Our ref: DOC26/169329-6

2 April 2026

### **EPA Advice on Submissions Report – Kurnell Refinery MOD 7 Infrastructure Consolidation and Remediation – SSD-5544-Mod-7**

Construction Noise Contours

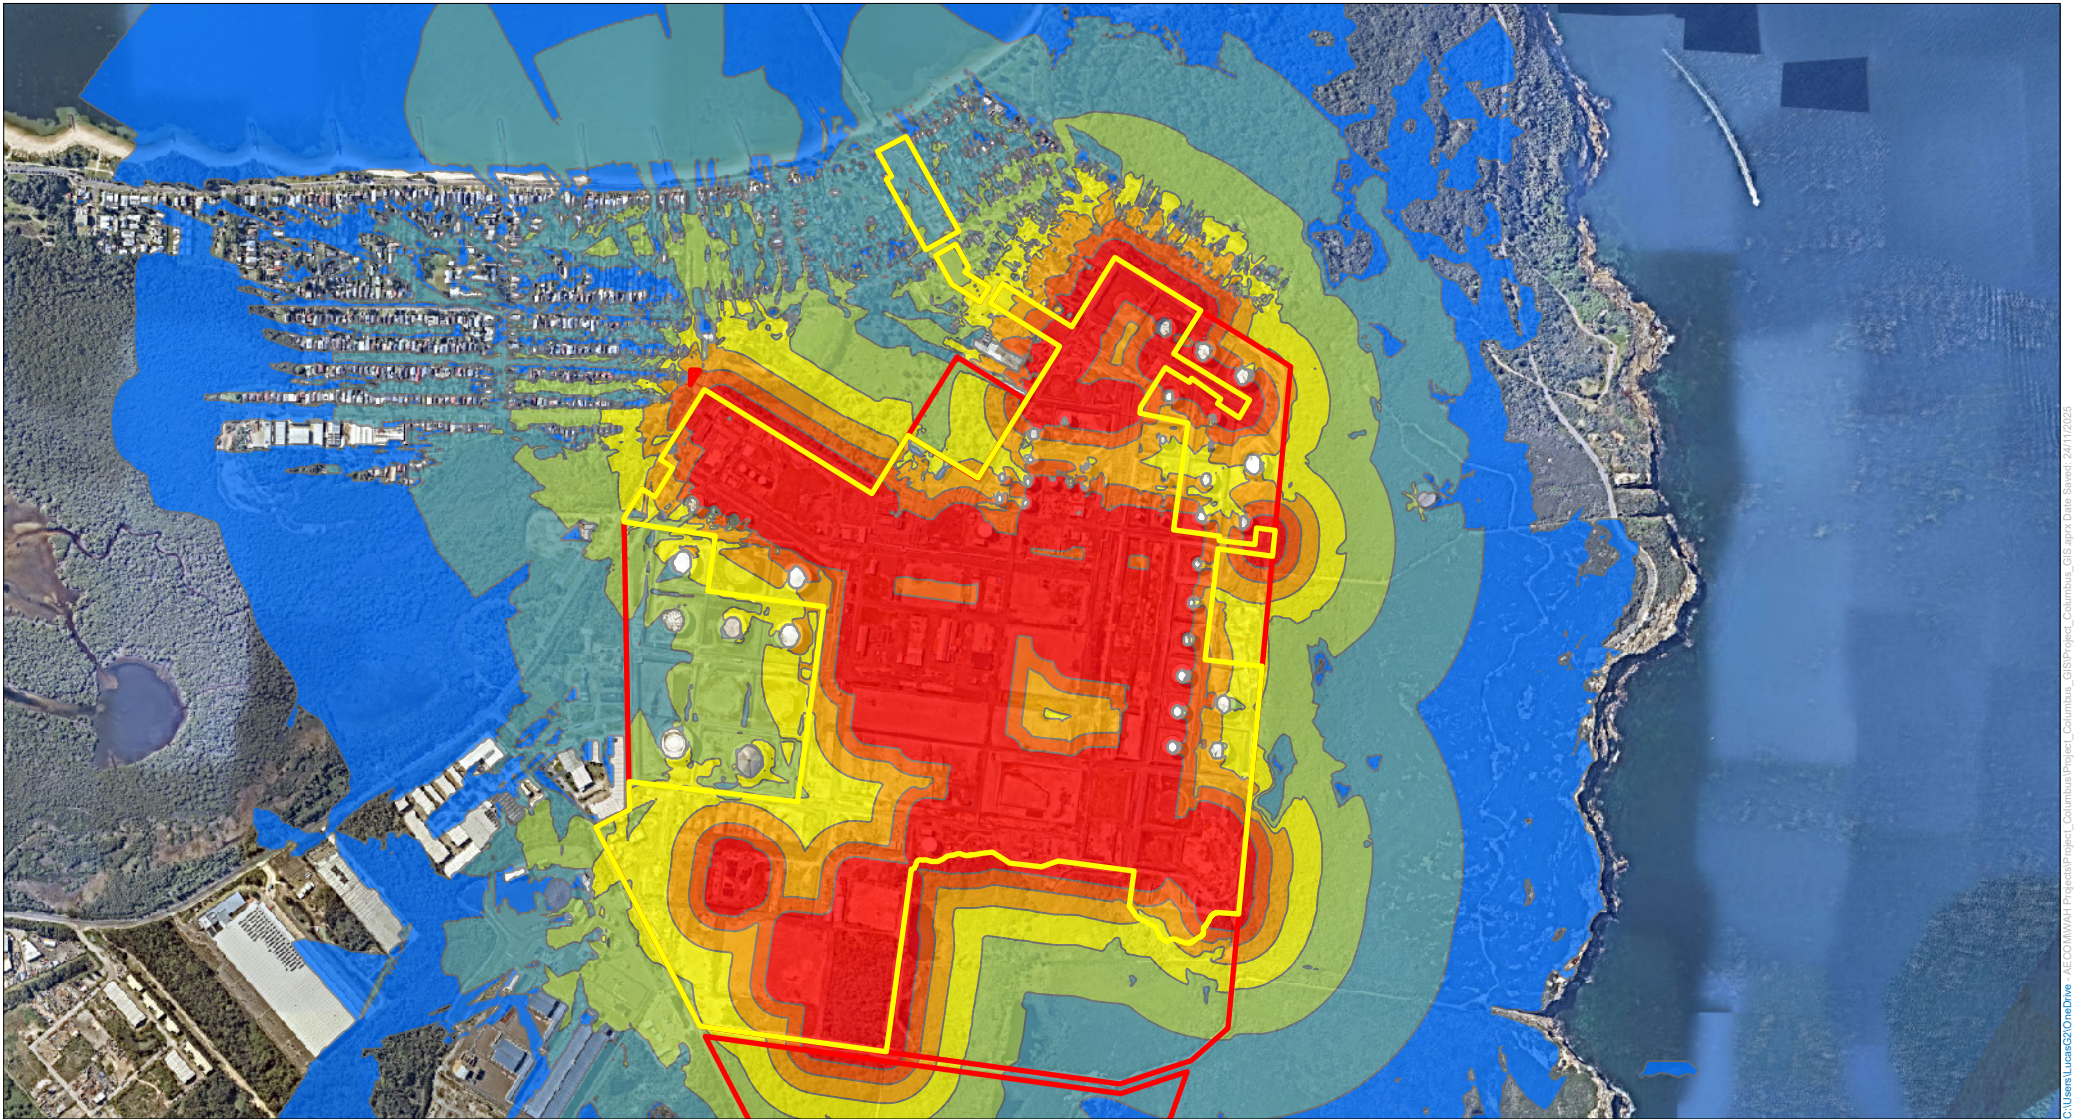
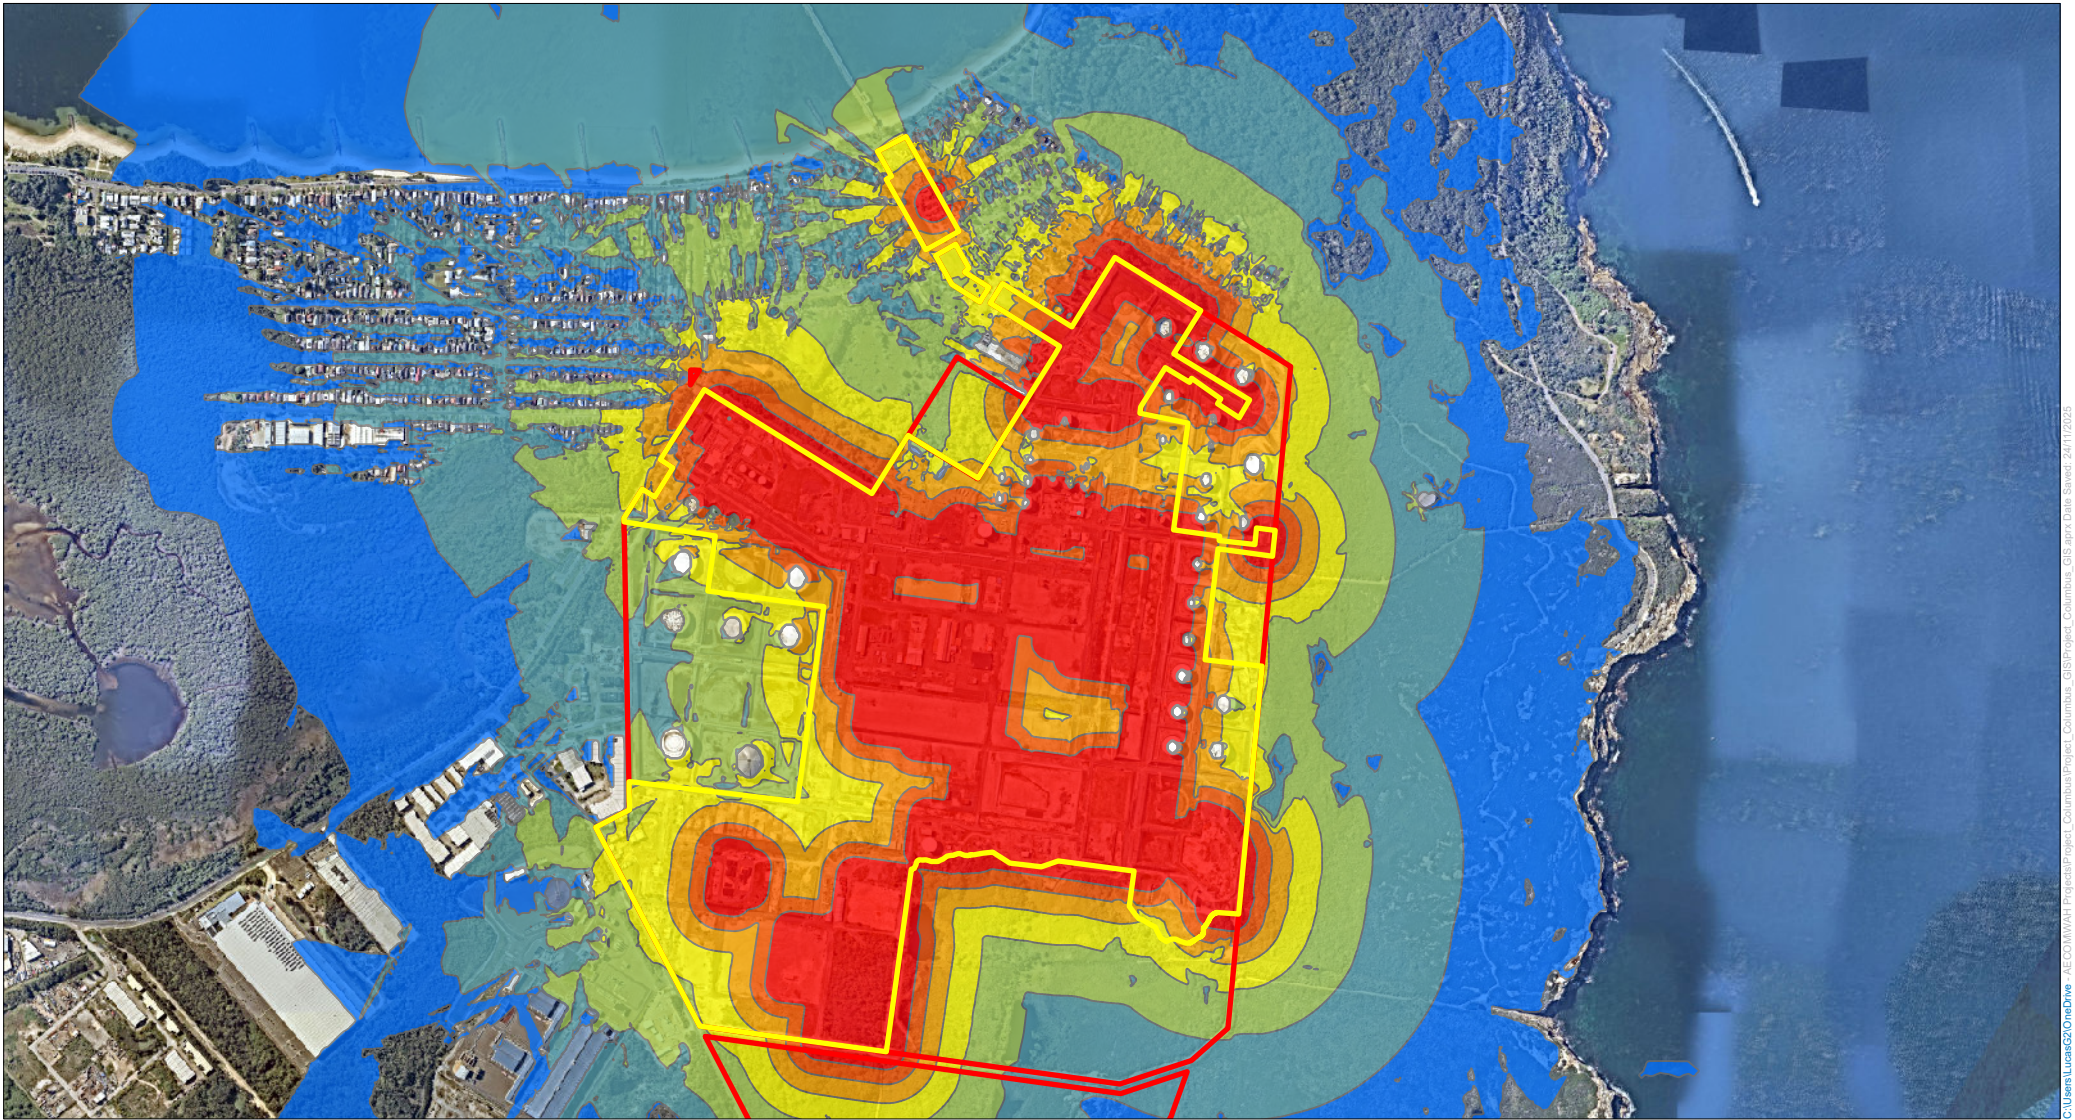
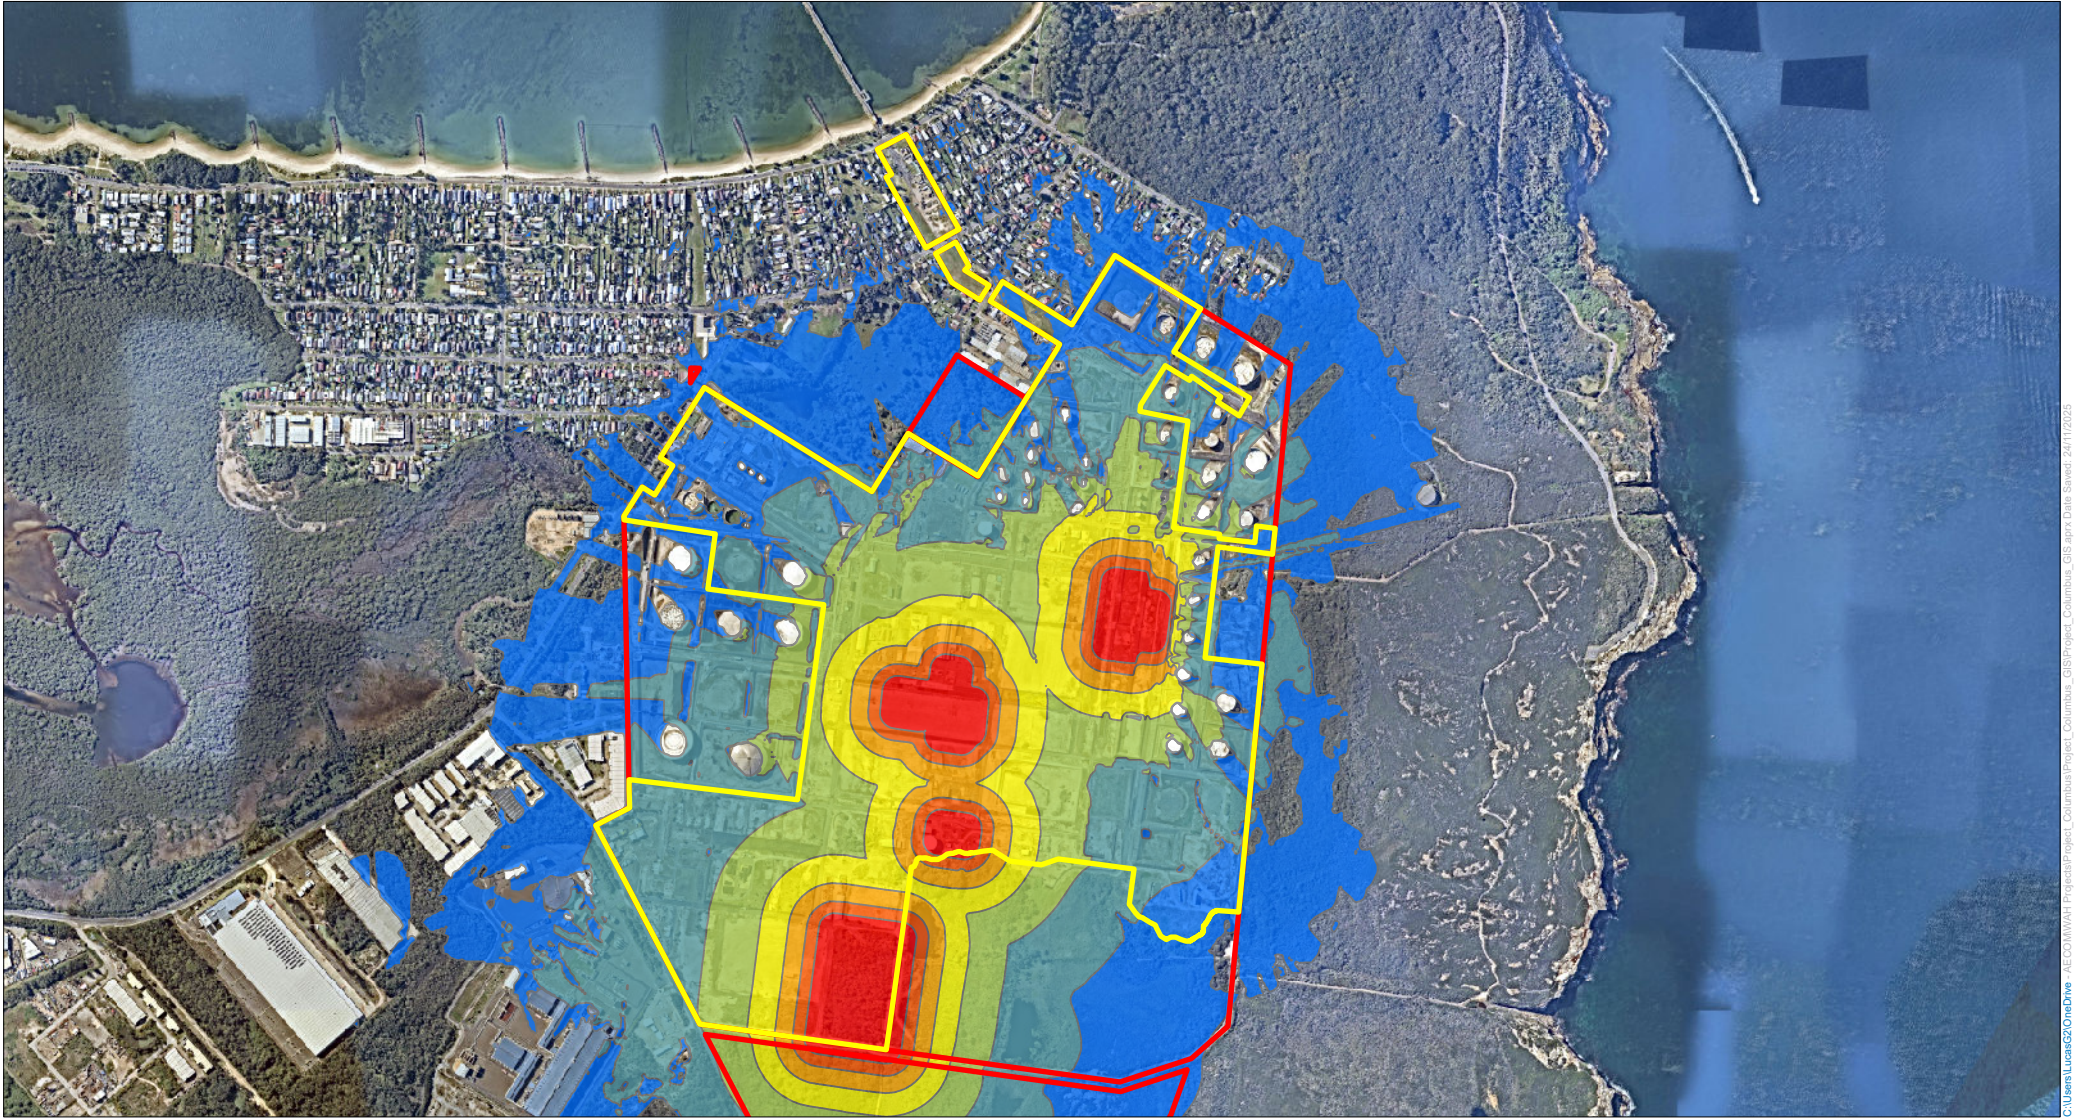
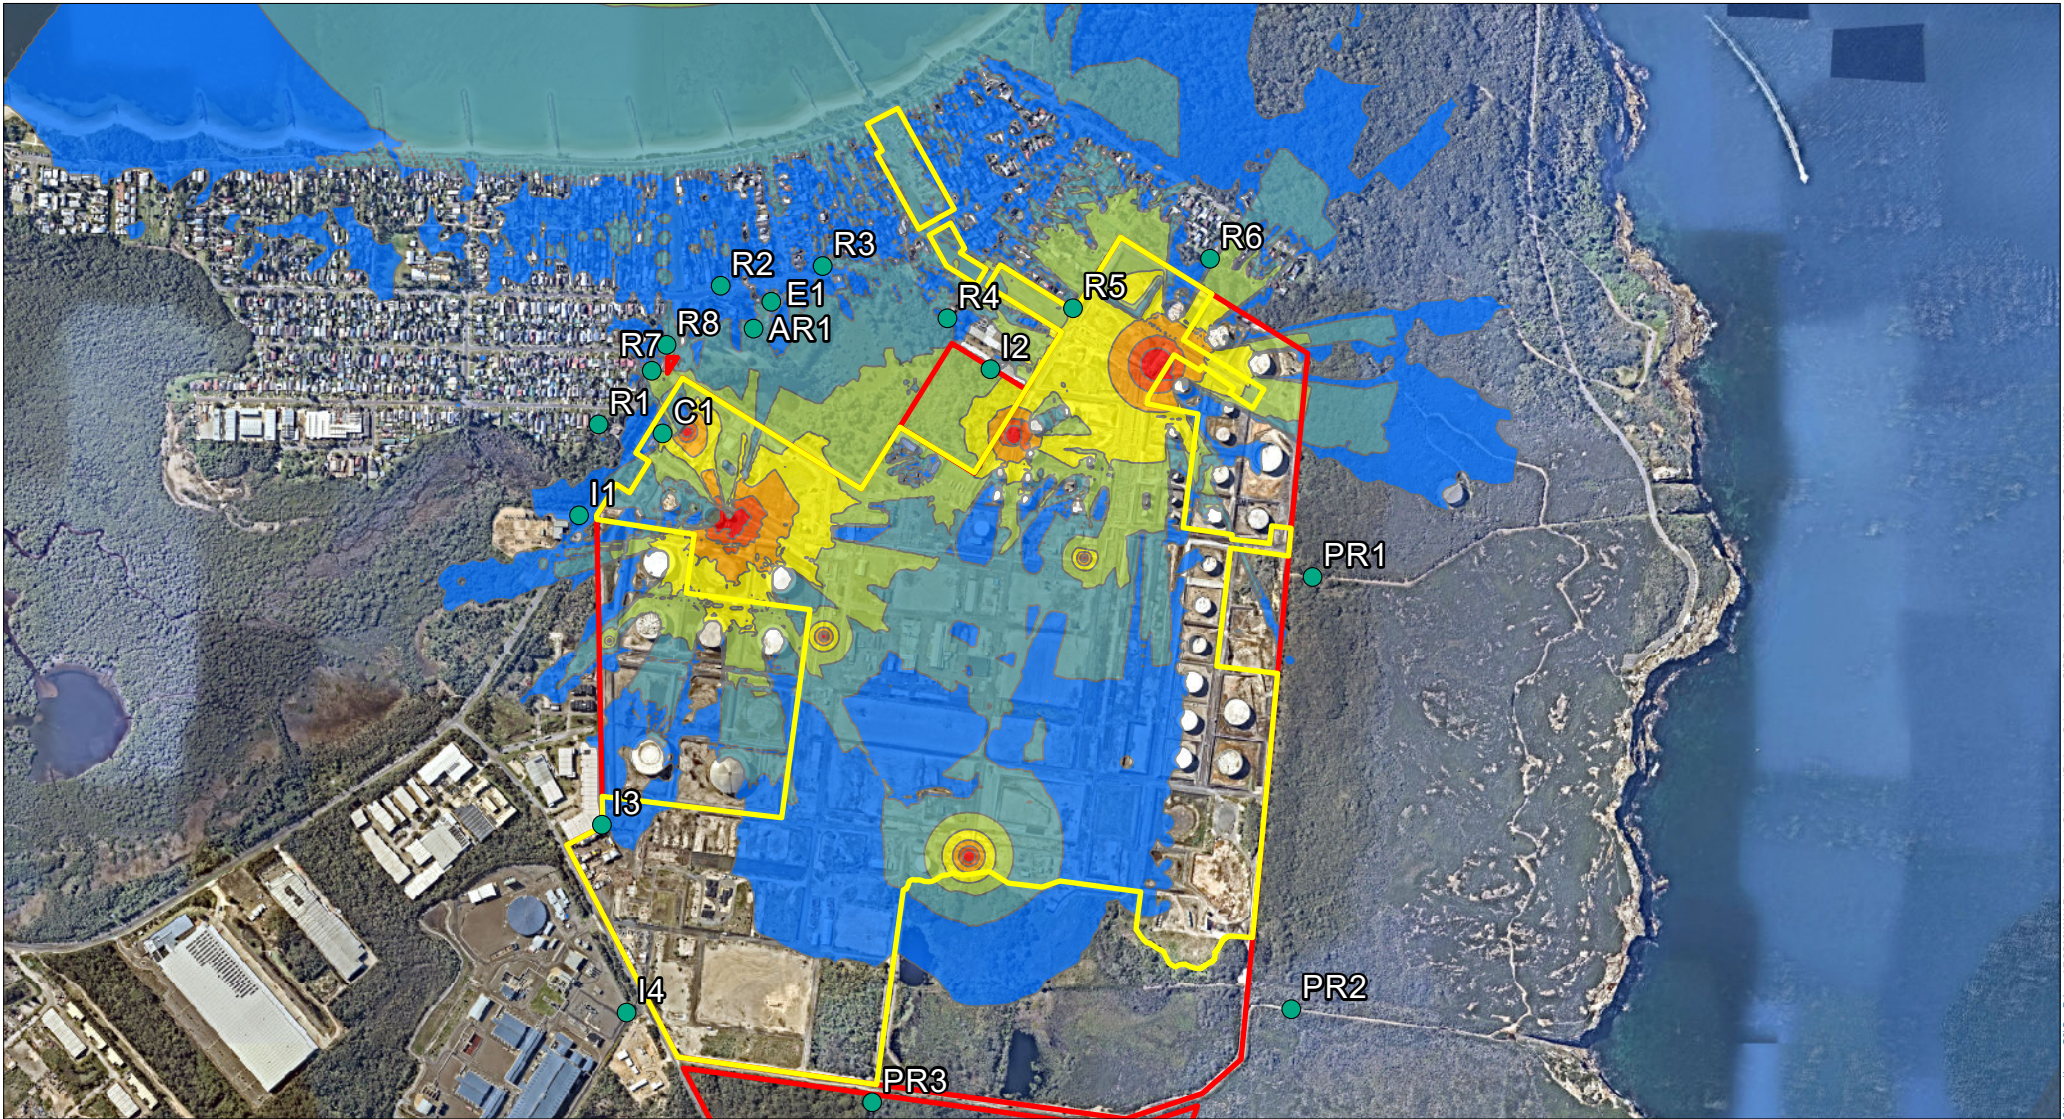
The updated noise contour maps provided in the Updated Noise & Vibration Impact Assessment (UNVIA) indicate that the selected receiver locations (Receivers R1 to R6) may not be representative of the predicted impacts at the surrounding residences. For example, the first contour map in Appendix B of the UNVIA, receivers R5 and R6 appear to have been selected to represent the residences in and around Sharn Street, Captain Cook Drive, Reserve Road and Polo Street. The predicted noise levels for R5 and R6 during normal operations under noise enhancing meteorological conditions are Leq,15min 50 and 36 dBA respectively. However, the noise contour map indicates that receivers surrounding R6 may receive a substantially higher noise level than is reported in Table 5-2, given they appear to be in the 45-49 dBA contour band.

Where a select number of receivers are used to represent a larger area of sensitive receivers, the location should be carefully chosen to be representative of predicted impacts. The information provided in the UNVIA indicates that the currently selected receivers may not be representative of impacts across the surrounding sensitive receivers, and alternative and additional locations may be required.

The EPA recommends that DPHI consider requesting the Applicant review the receivers used to represent impacts at surrounding sensitive receivers to ensure that they are representative of potential impacts and amend the assessment accordingly.
